August 25, 2017

Re: Academy Village Filing Number 3- Drainage Addendum Letter

This letter is an addendum to the “Final Drainage Report for Academy Village” dated April 1999, prepared by HMS Group, LLC. This addendum will address the reconfiguration of the drainage pattern within basin 1a of the approved report. The purpose of this addendum is to quantify the changes to the drainage condition due to site variations from the approved report.

ACADEMY VILLAGE FILING NO. 3  
 POND GRADING PLAN  
 SHEET 5 OF 6  
 JOB NO. 25123.00

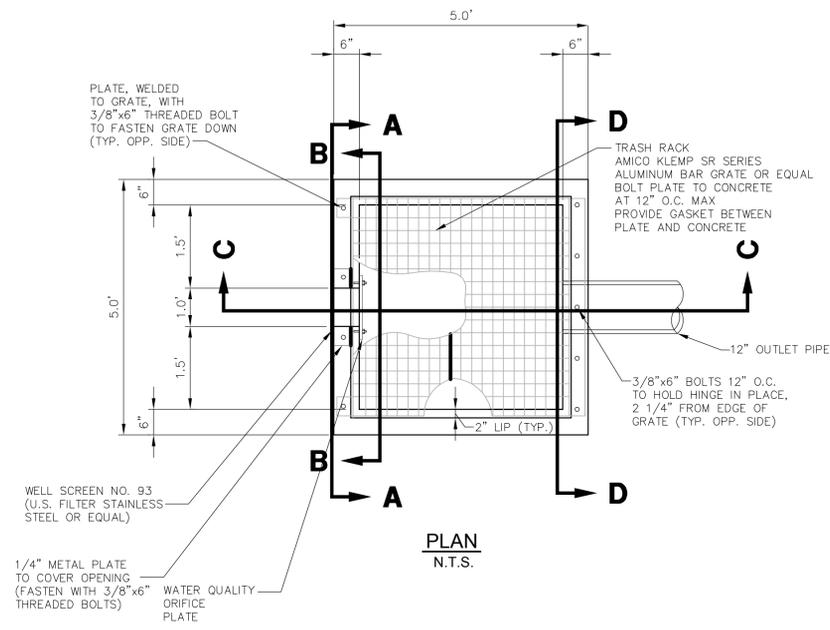
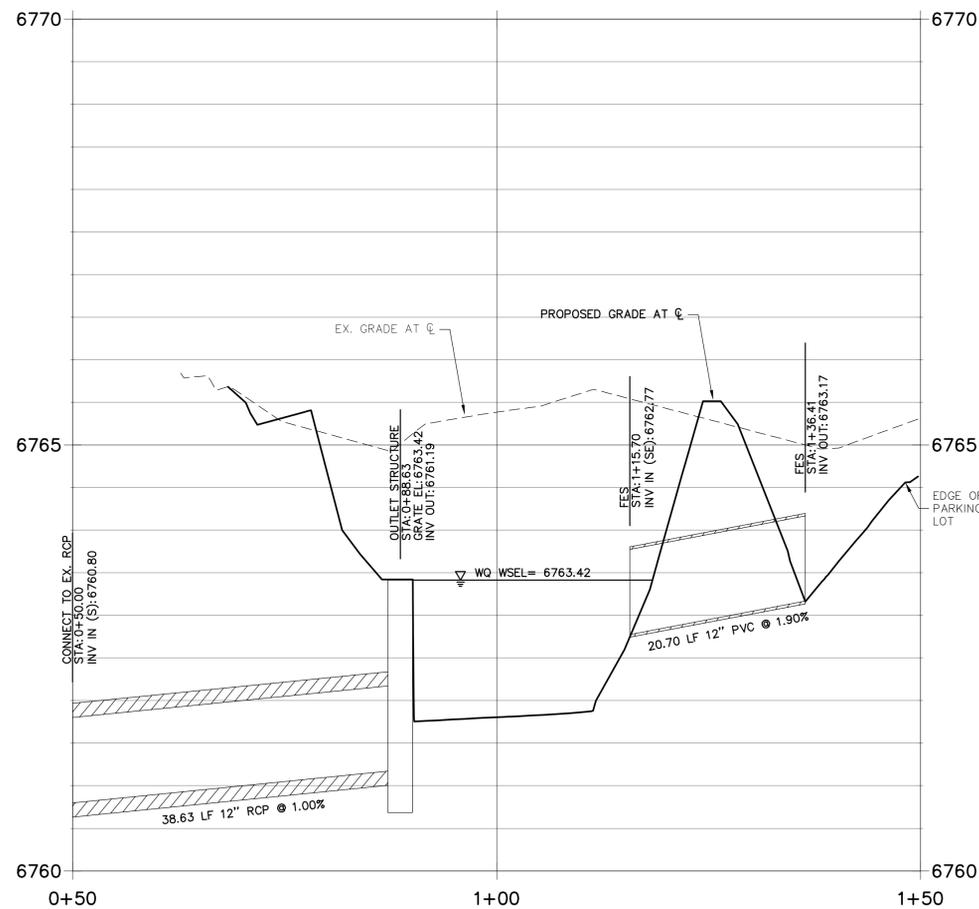
describe type of pond (PLD/rain garden), provide details, etc. Reference ECM Figure I-3. Provide UD-Detention spreadsheet calculations.
